AB/14/26/DOC

Address: 6 High Street Arundel BN18 9AB

Proposal: Approval of details reserved by condition under AB/89/23/L relating to conditions 4- Method Statement (timberwork) and 5- Method Statement (infill panels).

ARUNDEL BRIDGE ANTIQUES
 6, HIGH STREET, ARUNDEL.
 FRONT ELEVATION OF TIMBER FRAME AND
 PANELS TO HELP LOCATE AND RECORD
 AREAS OF REPAIR
 Scale: 1 — 20 Drawn: S.H.D.
 Drawing No A L (0) 6 Date: 22/09/23

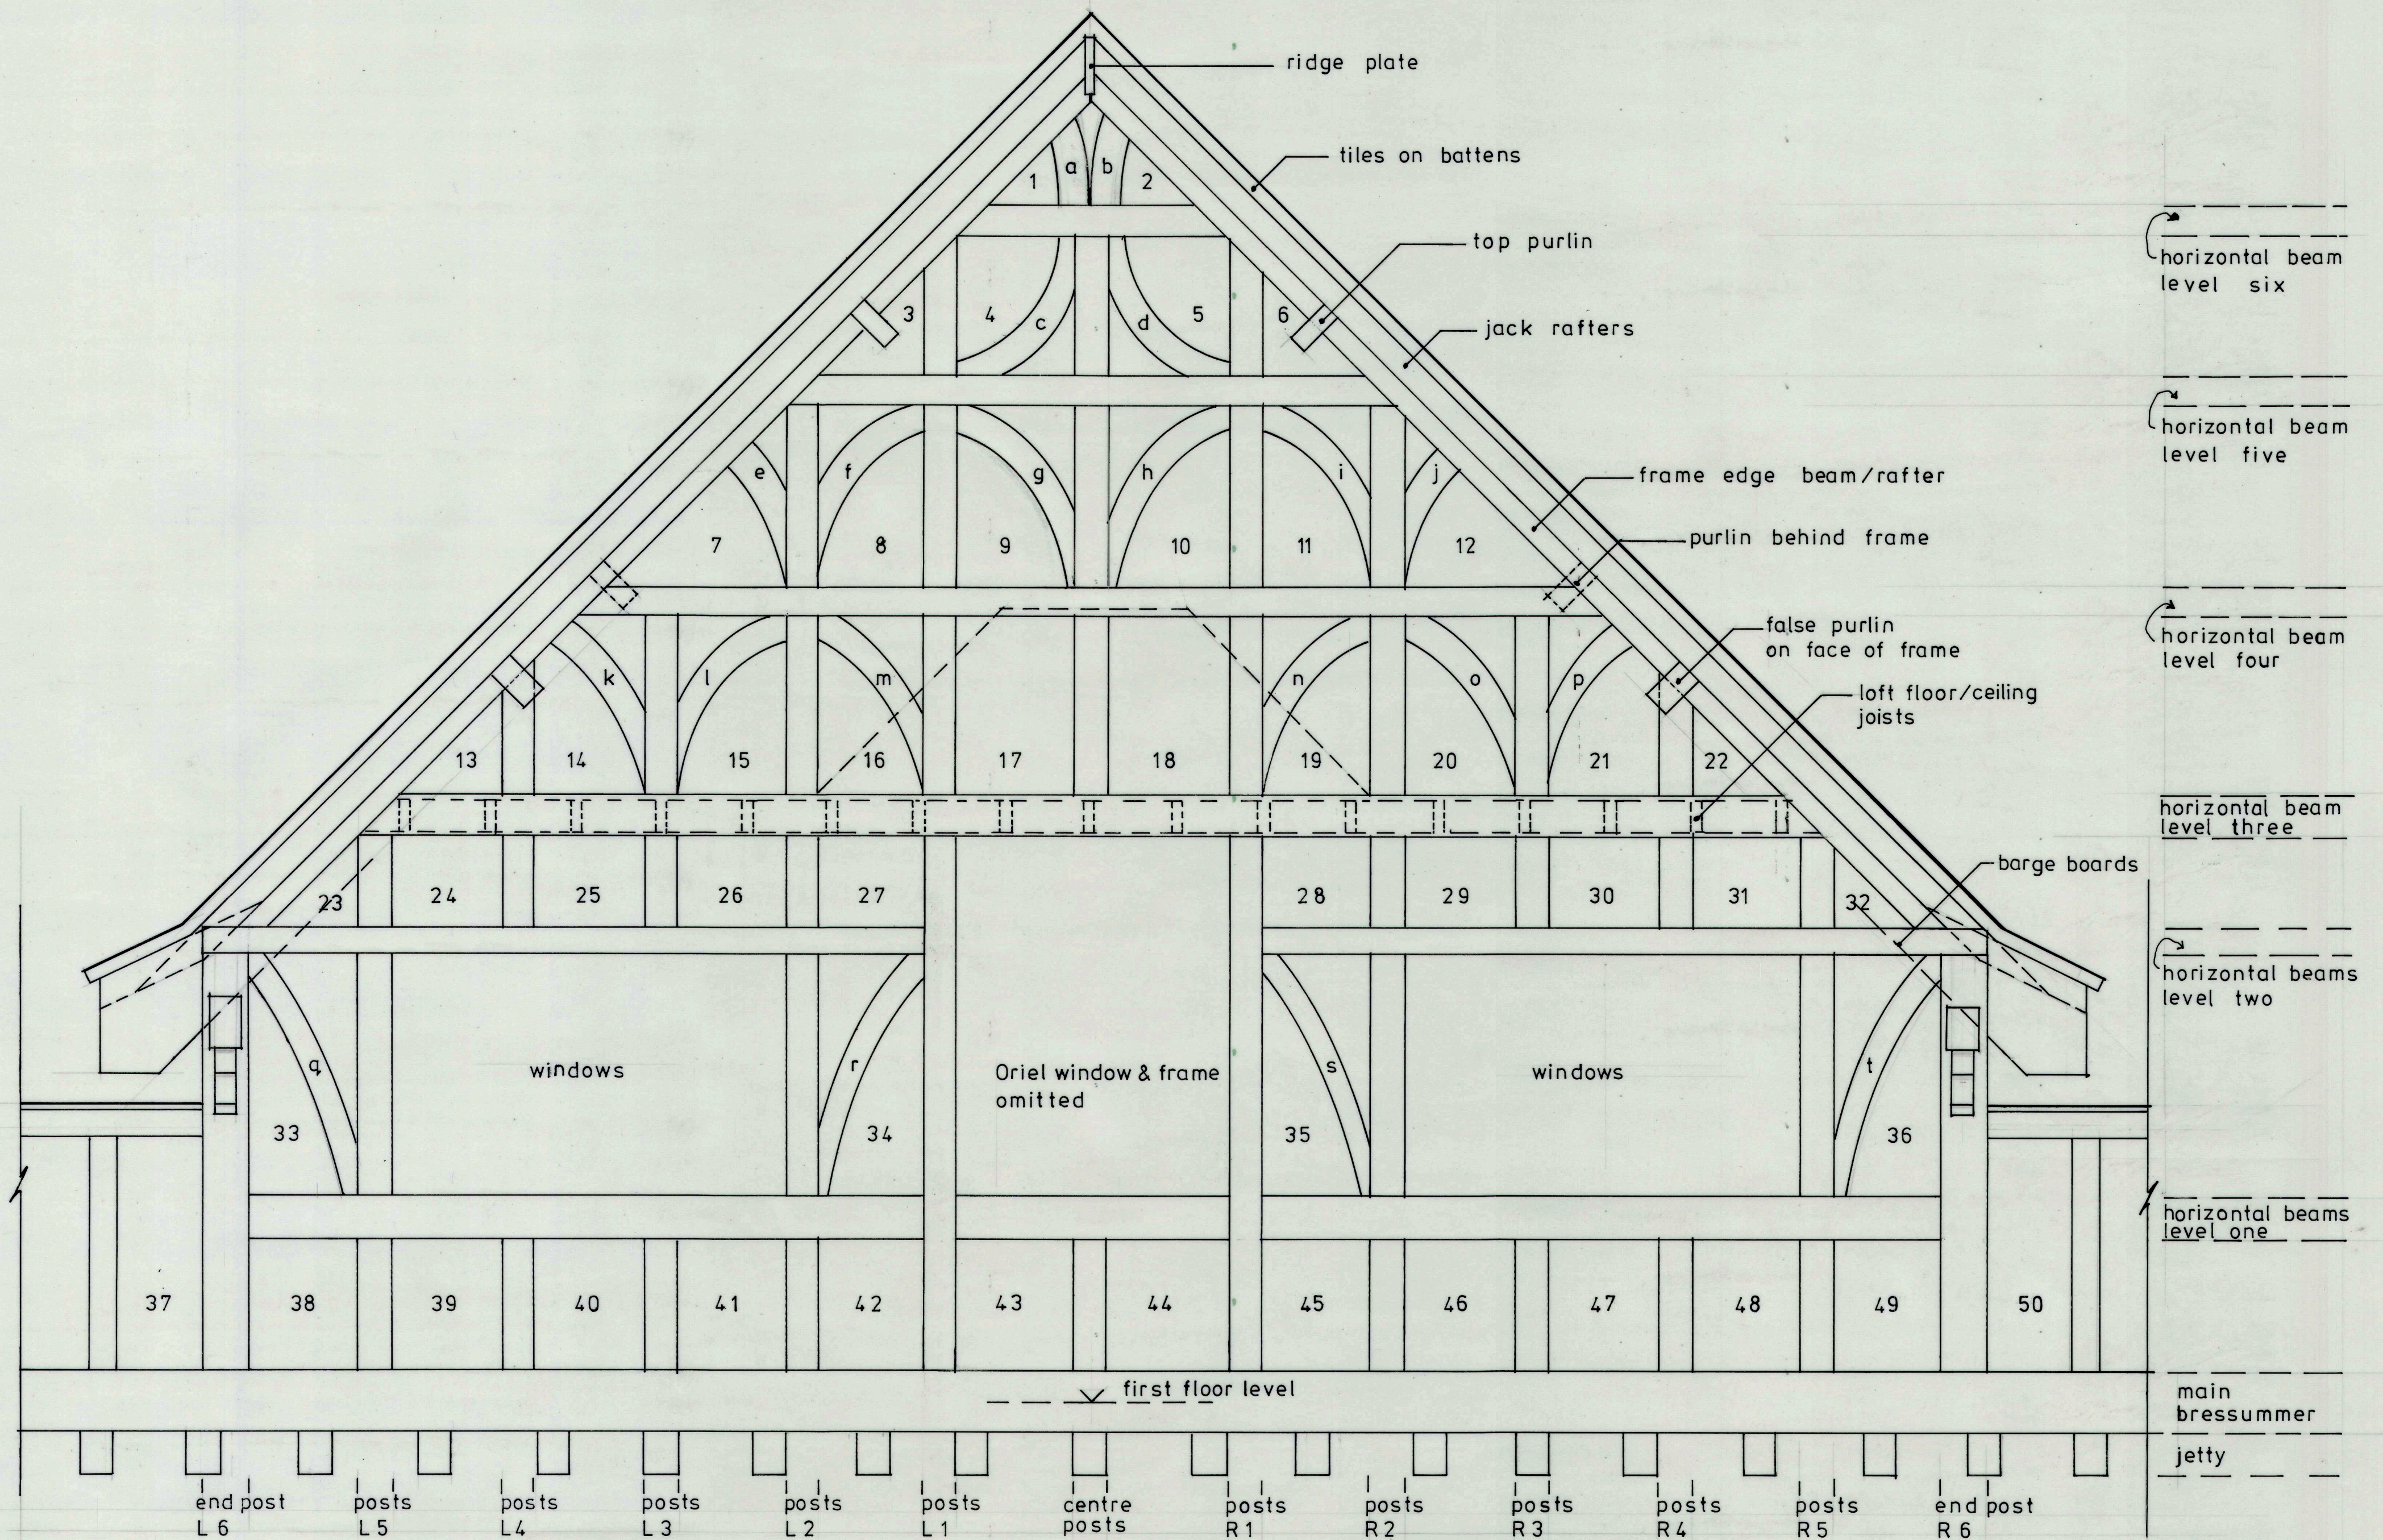
Whilst generally acceptable, it is not clear what colour will be used to stain/paint the timber. If this was not part of the original application this should be conformed? It should be to match the existing.
